The Secretary
NSW Department of Planning, Industry and Environment

26 February 2021

I refer to the Department's letter of 14 January 2021 regarding State Significant Development SSD 3846 West Culburra Mixed Use Subdivision regarding the amended plans arising from Sealark Pty Ltd v Independent Planning Commission – West Culburra Concept Proposal Land and Environment Court Proceedings No 2019/78149 for land north of Culburra Road and west of the Culburra Beach township (Part Lot 5 & Part Lot 6 of DP 1065111 and Part Lot 1 DP 631825) in the Shoalhaven City Local Government Area (LGA). Submissions need to be made to the Department by 26 February 2021.

DRAWING STATUS		
DRAWING NUMBER	SHEET	REVISION
25405-37	1	10

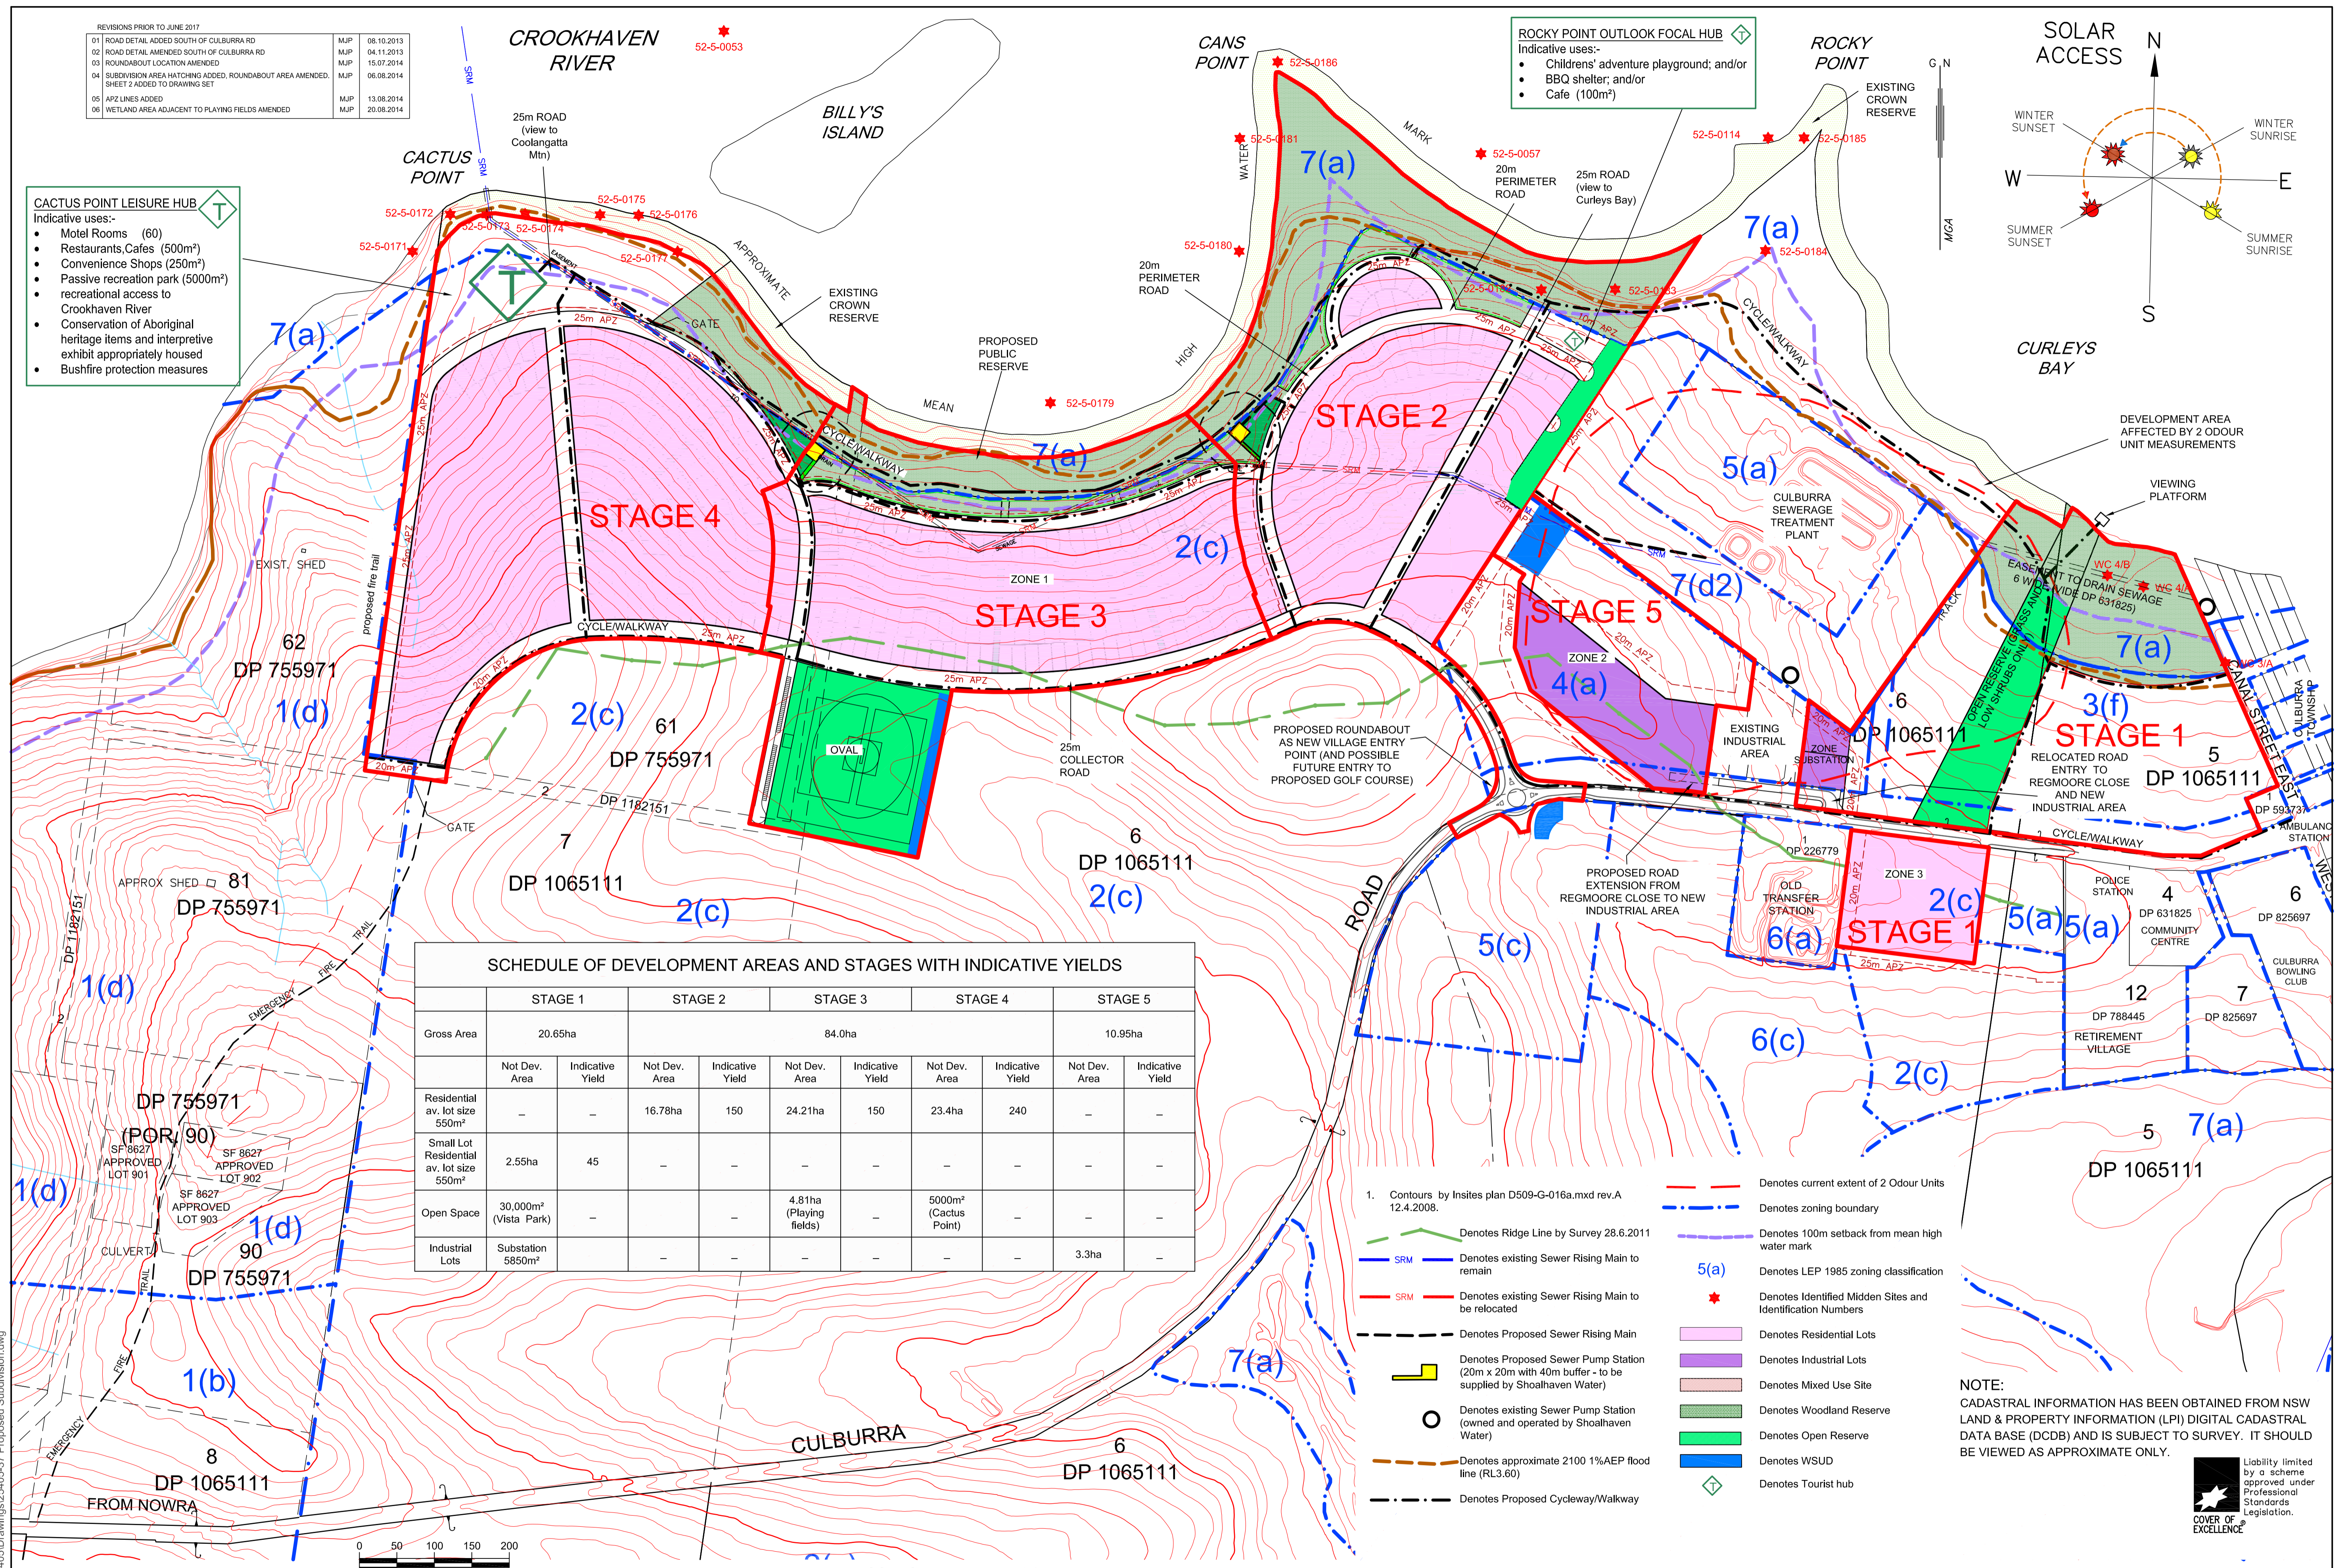
However, in the interim provision for a new zone substation and supply line still needs to be made. In this regard the updated Concept Plan no longer shows 'Zone Substation' on Industrial Land Lot 313 (5783 m²) on eastern side of Strathstone Street.
